**Our Ref: BR/209/19/PL**  
**Your Ref:**

**Town & Country Planning Act 1990 (as amended)**  
**Town and Country Planning (Development Management Procedure) (England) Order 2015**  
**Application for Planning Permission**

**Development** Garden shed to rear  
**Location** 9 Oak Grove Bognor Regis

Title: Garden Summer House

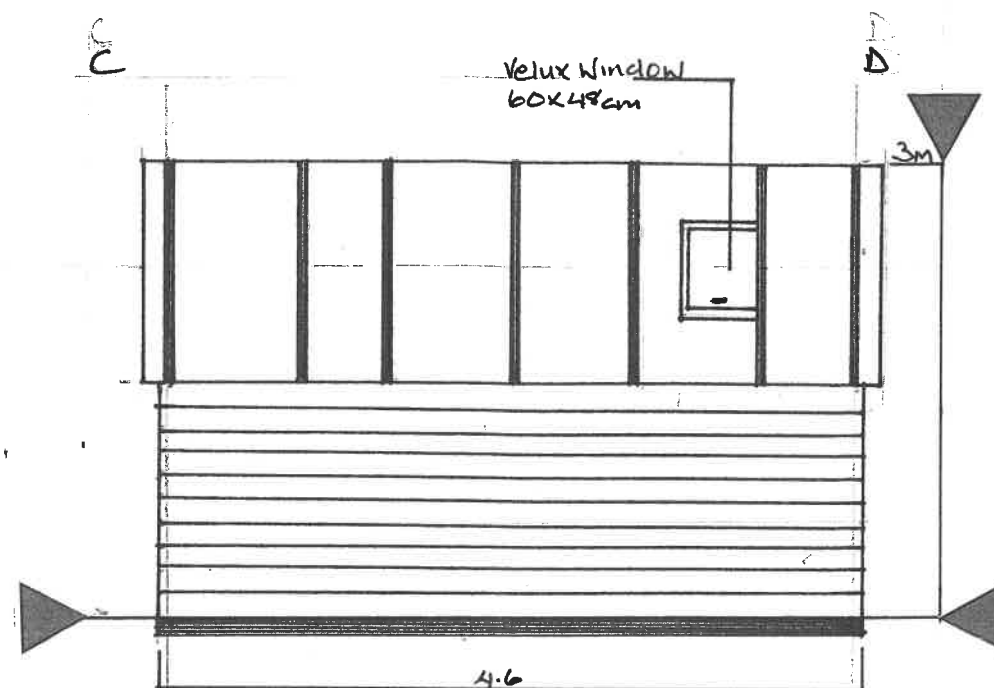
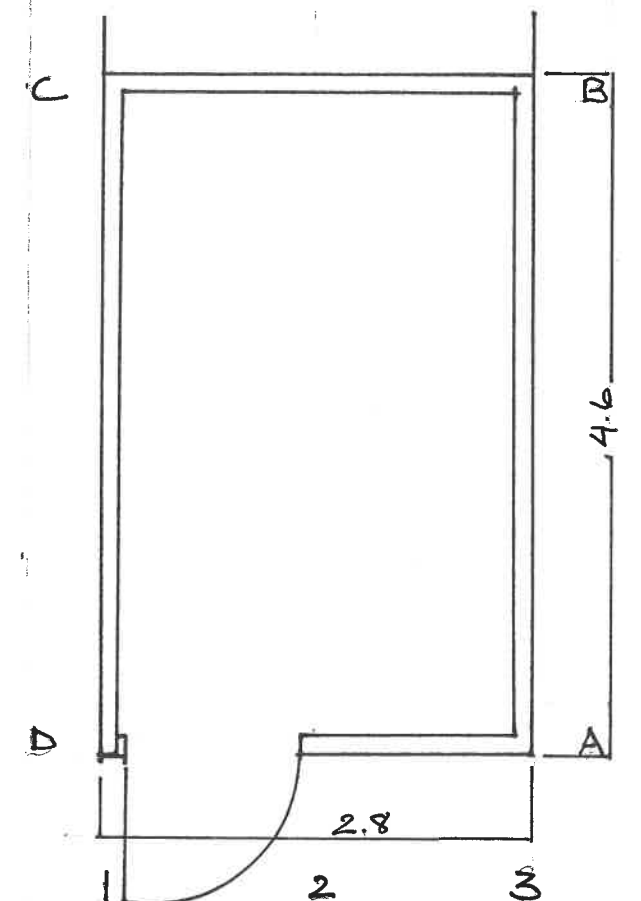
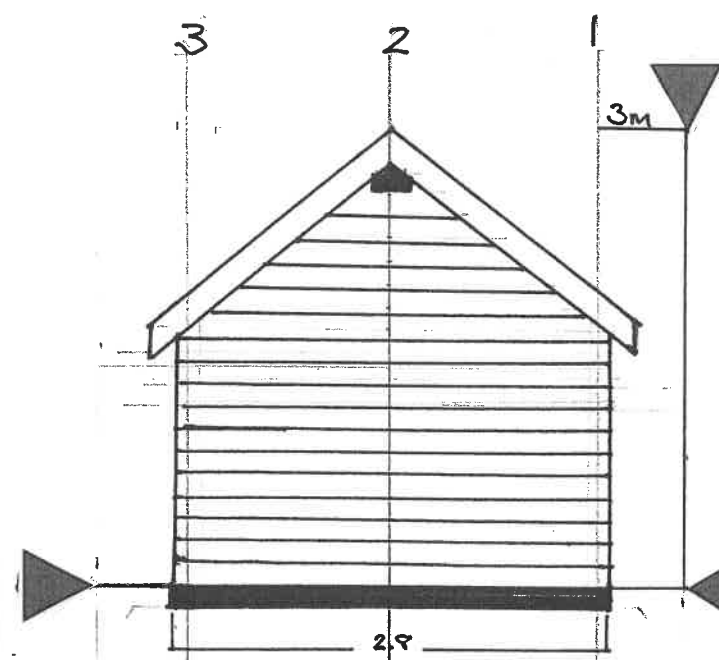
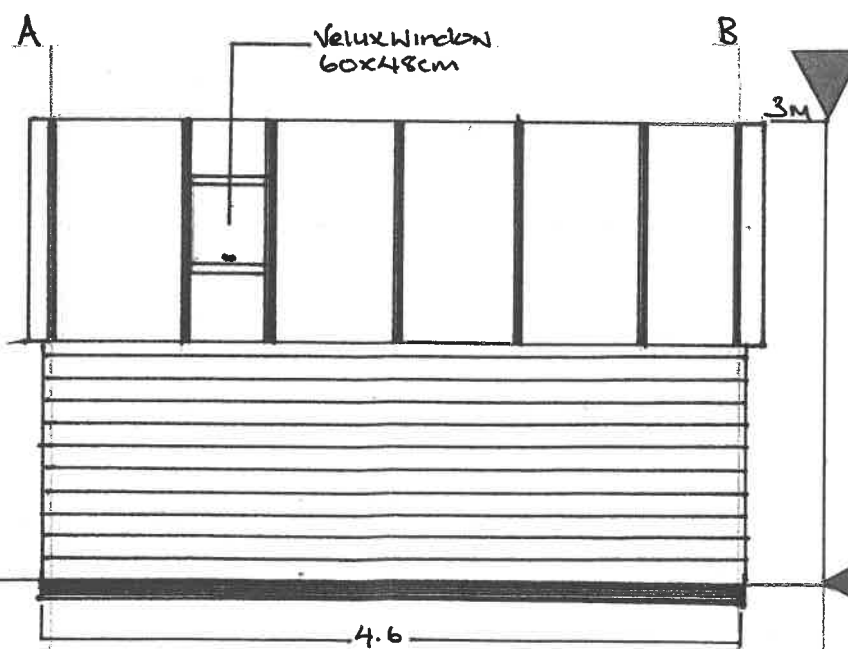
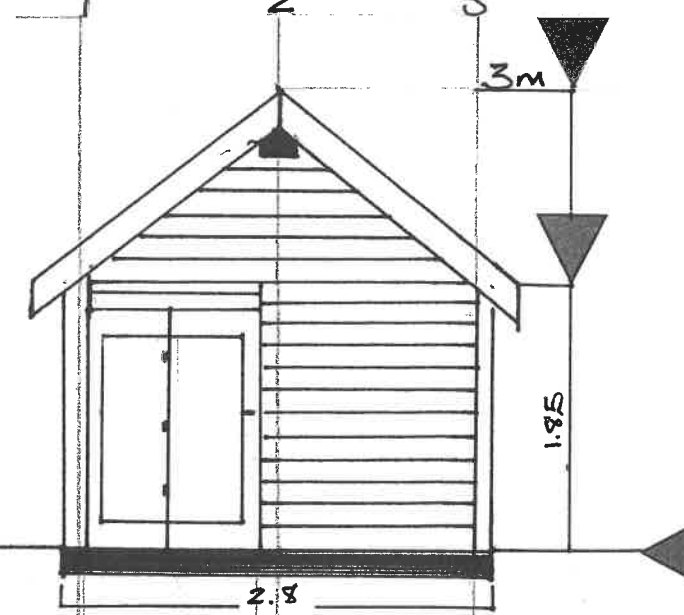
Please submit 1 electronic or 3 paper copies of amended floor plans at a scale of 1:50 or 1:100. The floor plans should be clear and show the openings to match floor plans

Please submit 1 electronic or 3 paper copies of amended elevations at a scale of 1:50 or 1:100. All elevations are required and this should be clear and show the openings to match floor plans
